Department of Primary Industries

OUT12/32858

**Windsor Bridge Replacement project (SSI-4951)
Response to exhibition of Environmental Impact Statement**

Windsor Bridge Replacement project (SSI-4951) Response to exhibition of EIS

Figure 5-5b | Access and circulation - Replacement Bridge

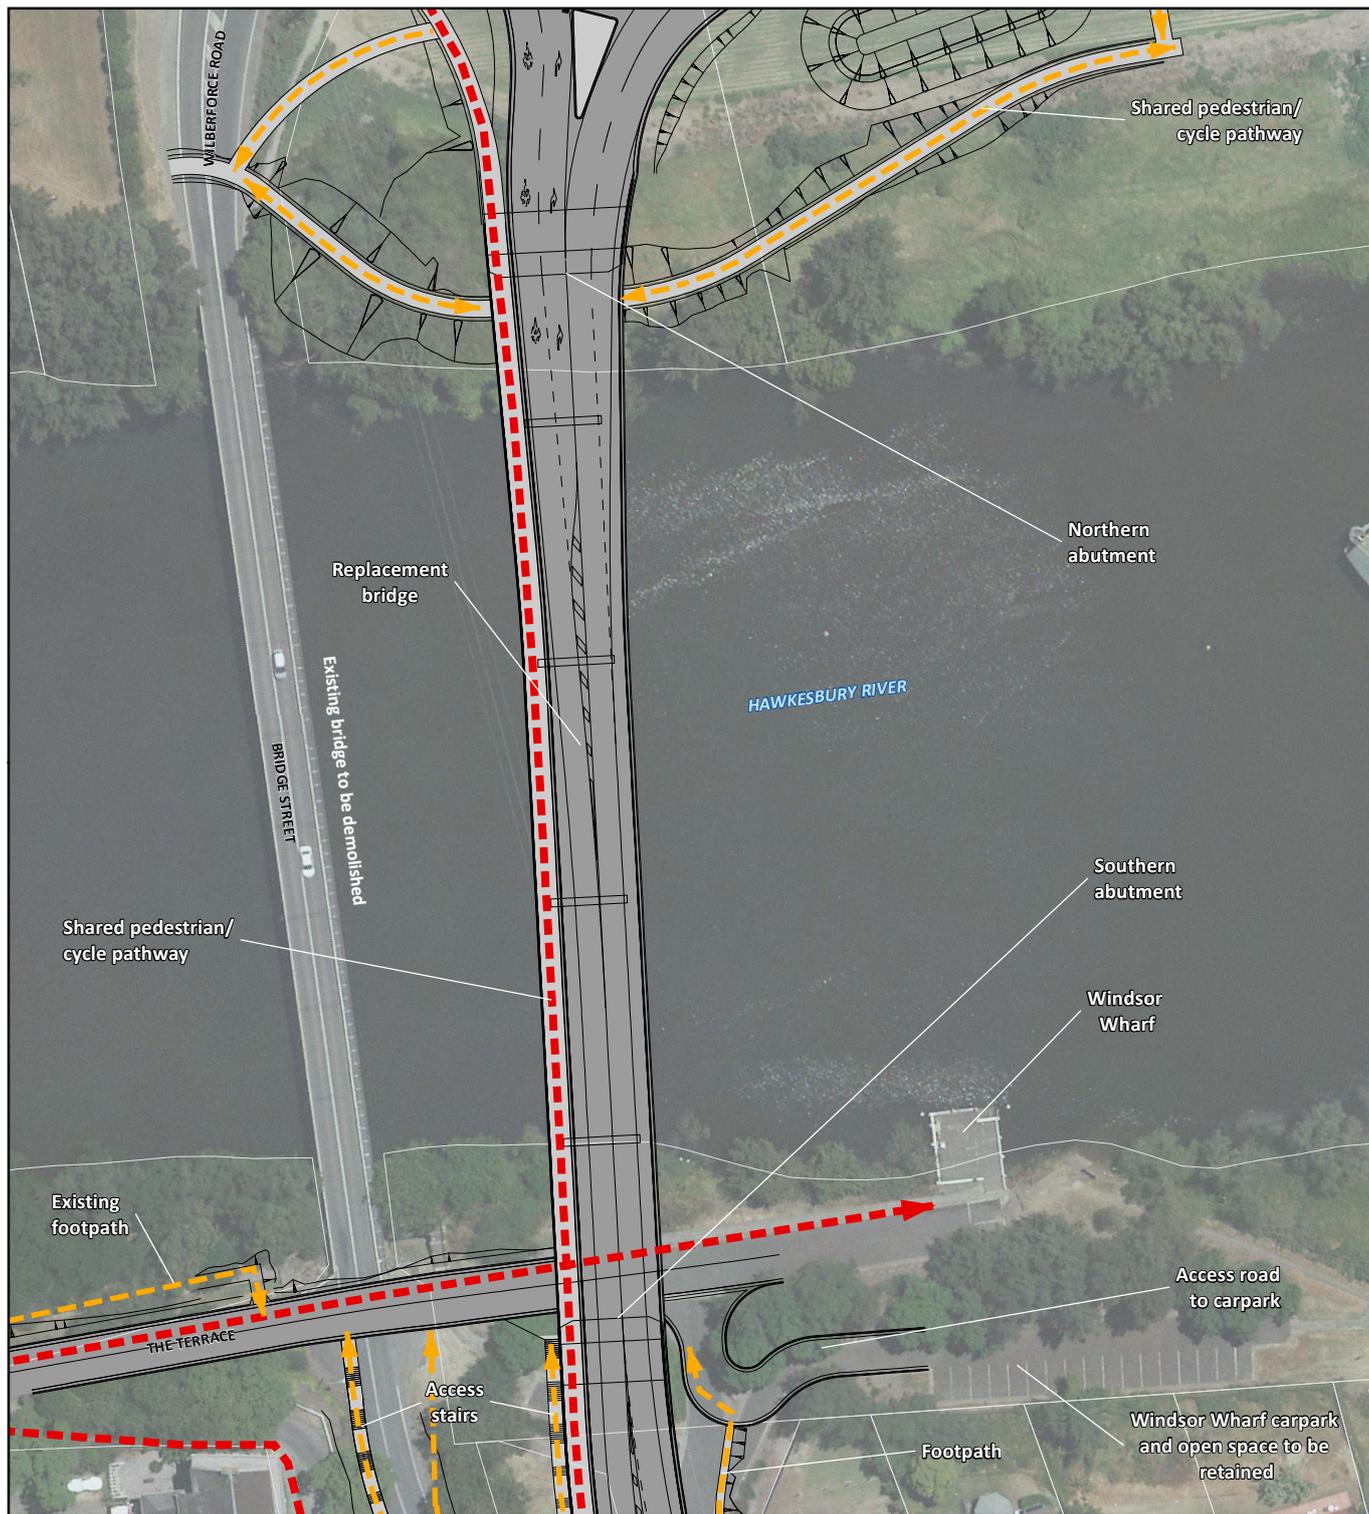
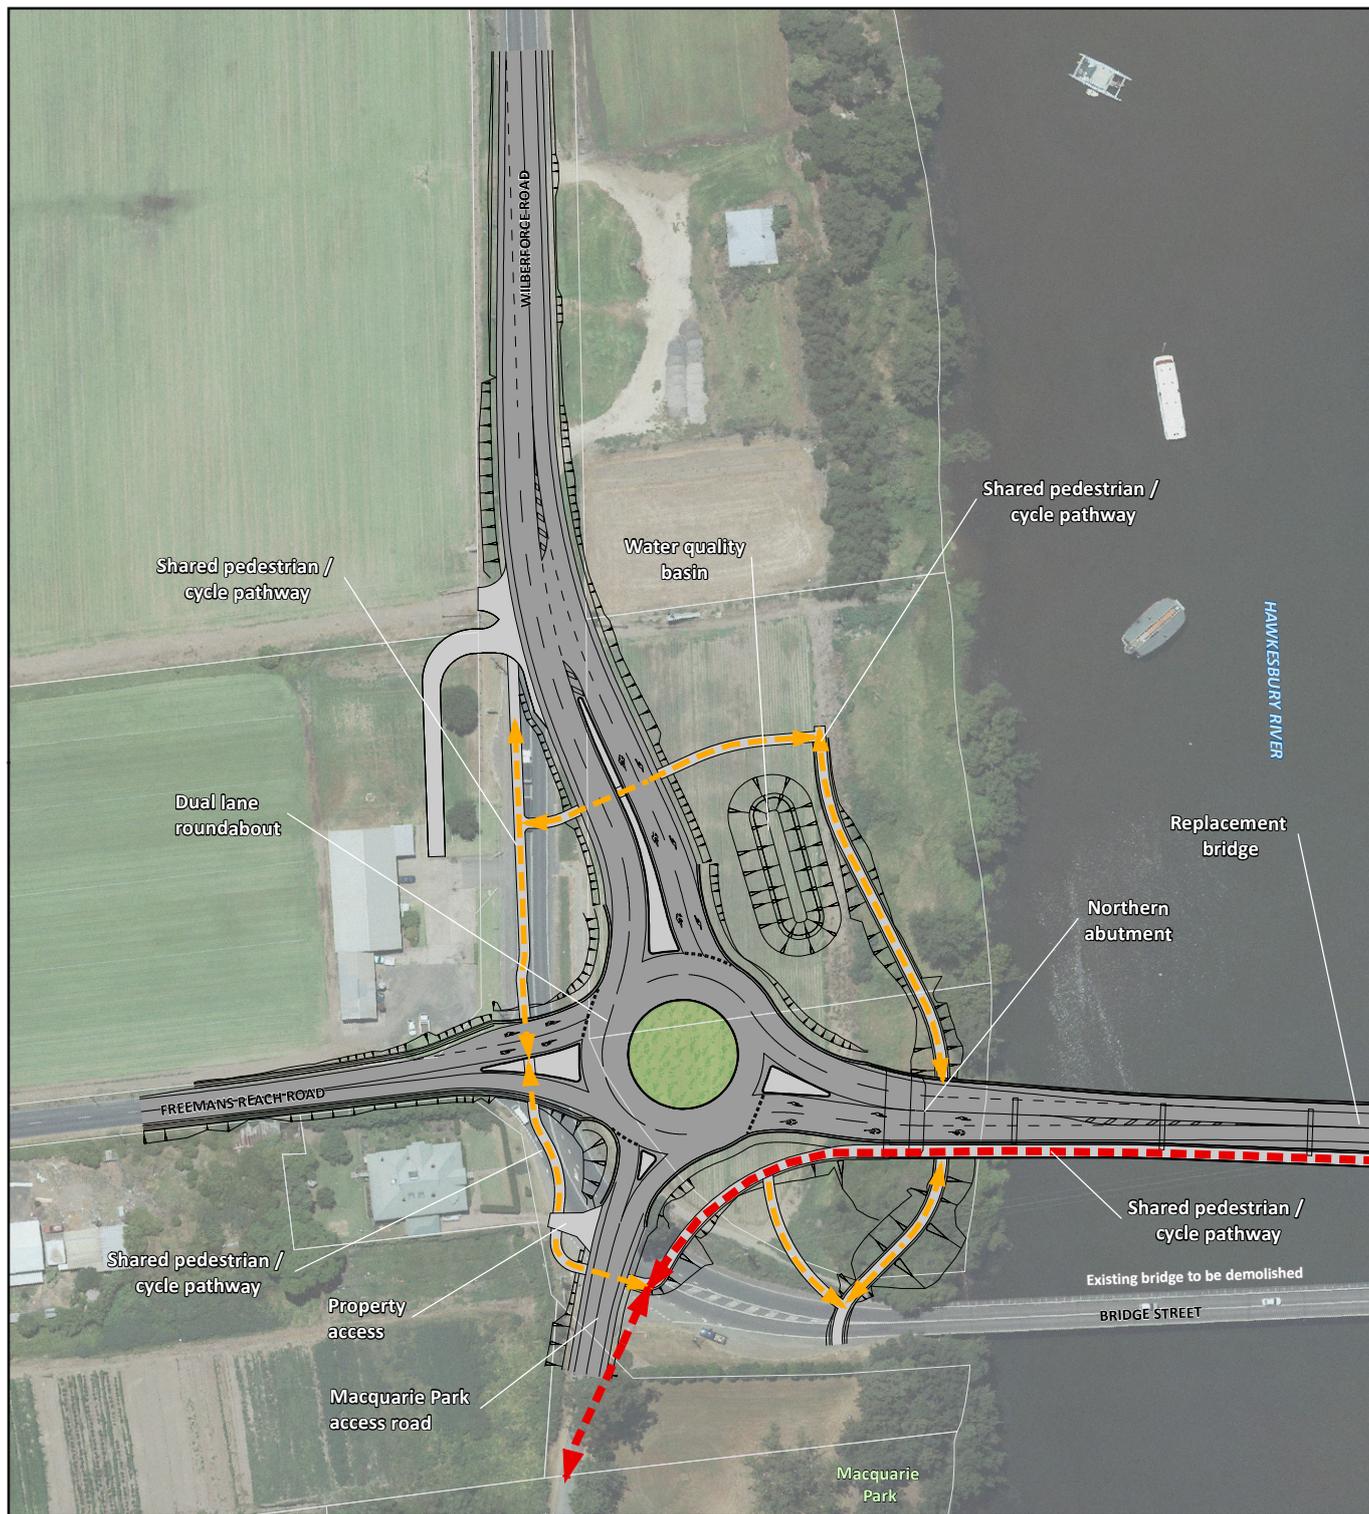
The EIS notes the project would include the construction of a permanent water quality basin on the northern bank to intercept and treat stormwater runoff. Based on Figures 5-5b and 5-5c the basin appears to be located outside the 40 m wide riparian corridor. The Office of Water supports the proposed planting of the basin with native riparian species (page 273) and planting the perimeter with native species (page 271). It is recommended local native plant species from the local vegetation community are used.

In addition, it is recommended the basin and any outlet structure be consistent with the following:

- *Guidelines for riparian corridors on waterfront land* (July 2012)
- *Guidelines for outlet structures on waterfront land* (July 2012)
